From: Alison Crabb [REDACTED]
Sent: 20 April 2015 10:48
To: Planning.Responses
Subject: RE: Planning Consultation on: BN/10/15/HH

APPLICATION **BN/10/15/HH**
NO:

Registered: 31st March
 2015
Site Address: Catbells Lake Lane Barnham PO22 0AD

Description of Single storey extension to front elevation to provide enlarged

PROPOSED SECOND FLOOR PLAN

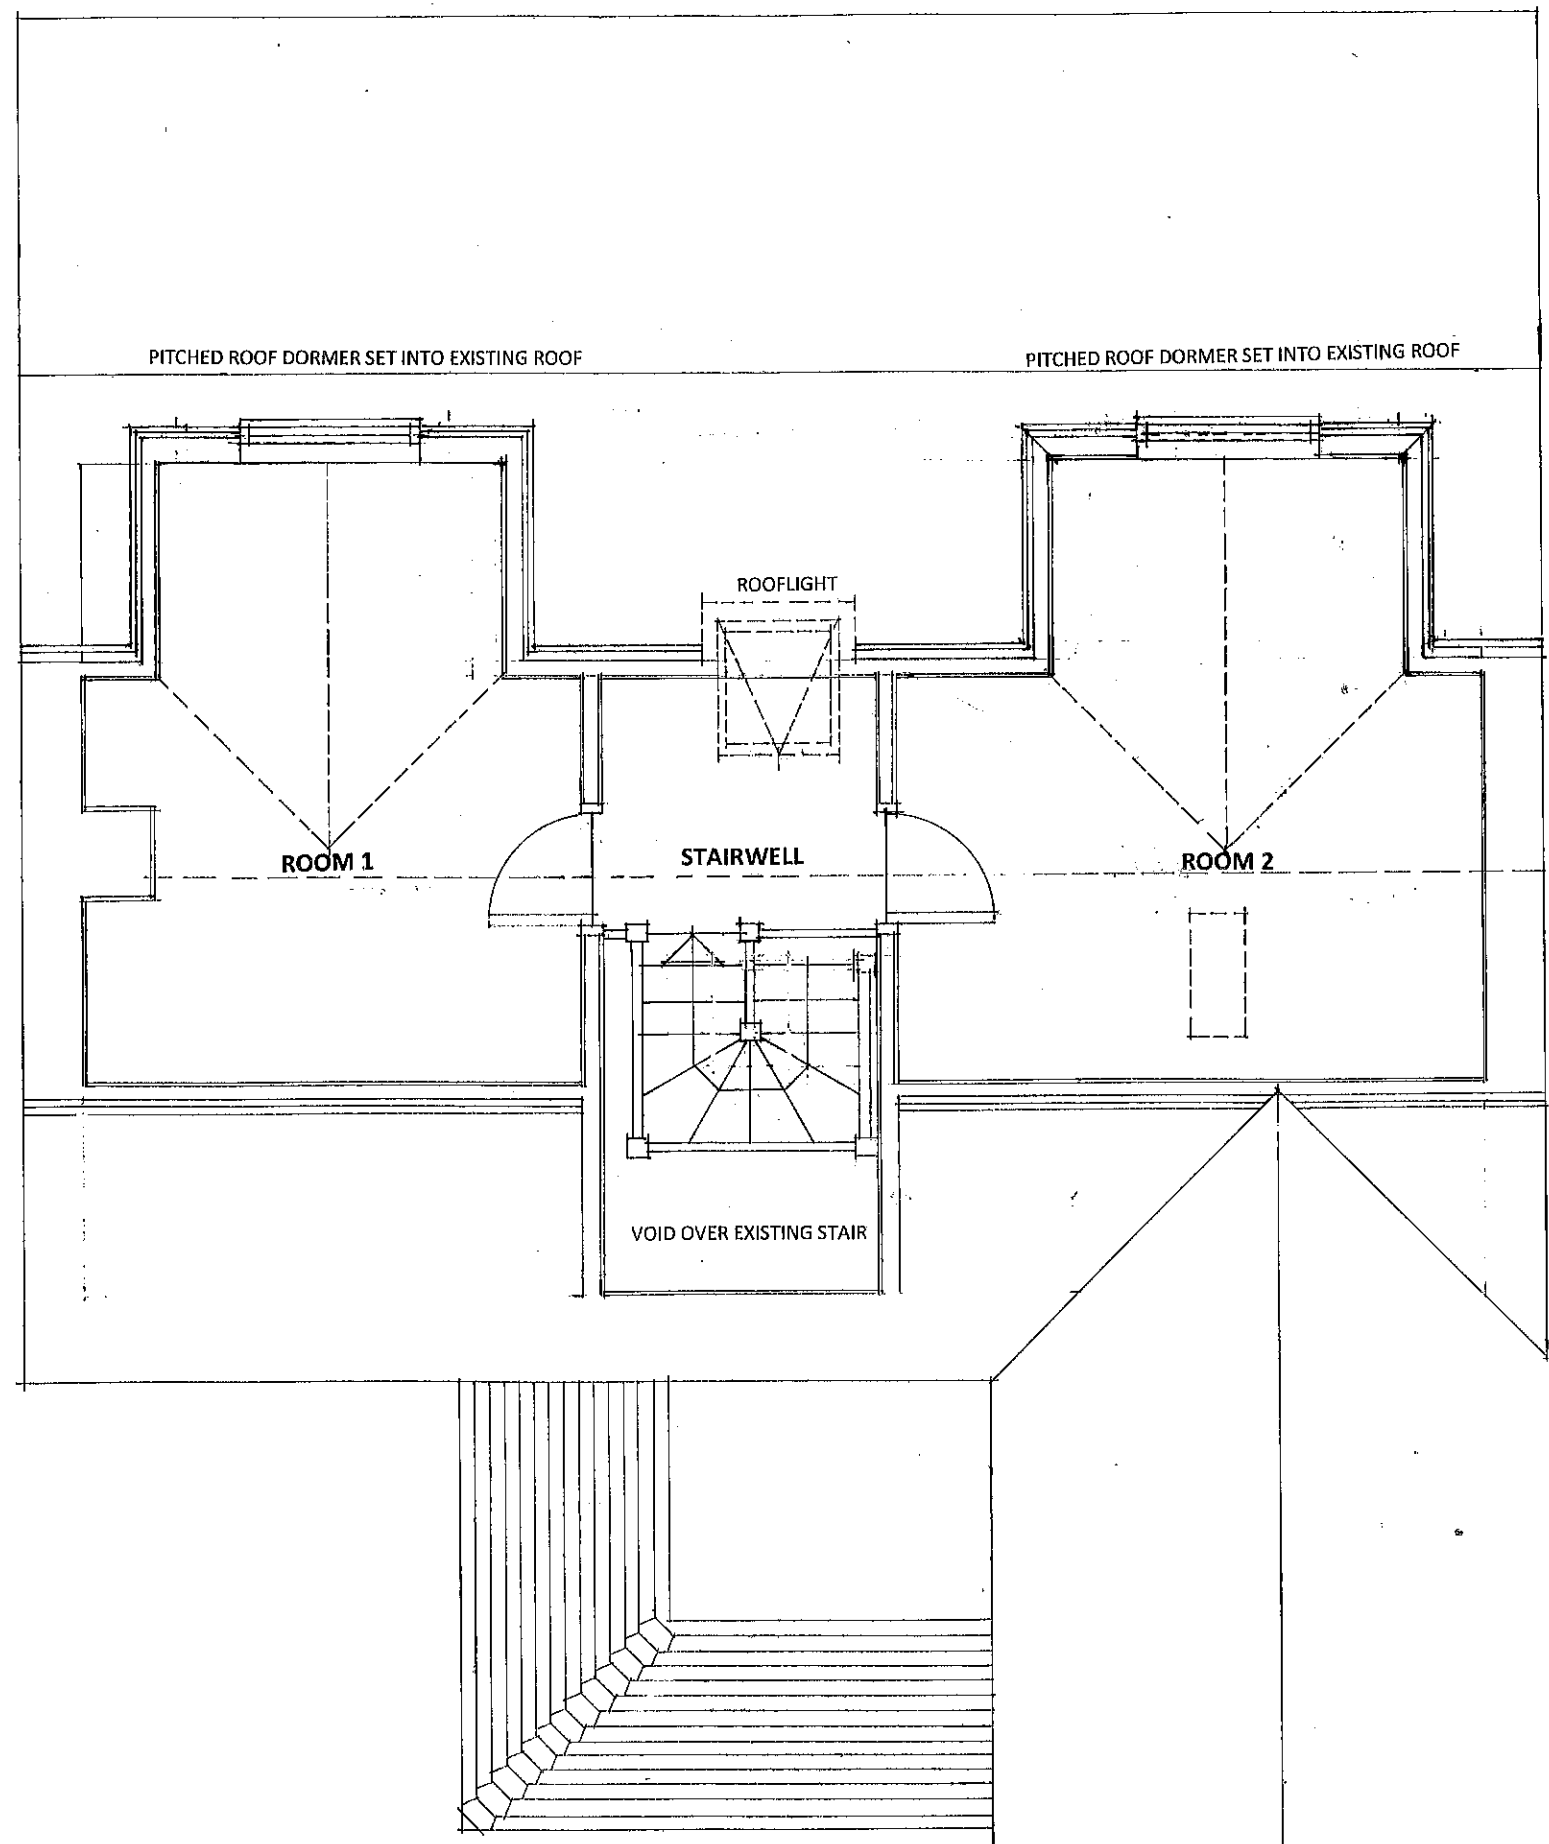
Barnham Parish Council has considered the above application via email discussion as no meeting is due to take place until after the elections. They wish to object to the application in respect of the proposed dormer windows which as well as causing privacy issues for adjoining properties in Halliford Drive contravene the Neighbourhood Plan policy ES6: Contribution to local character. The rest of the proposed application details are acceptable.
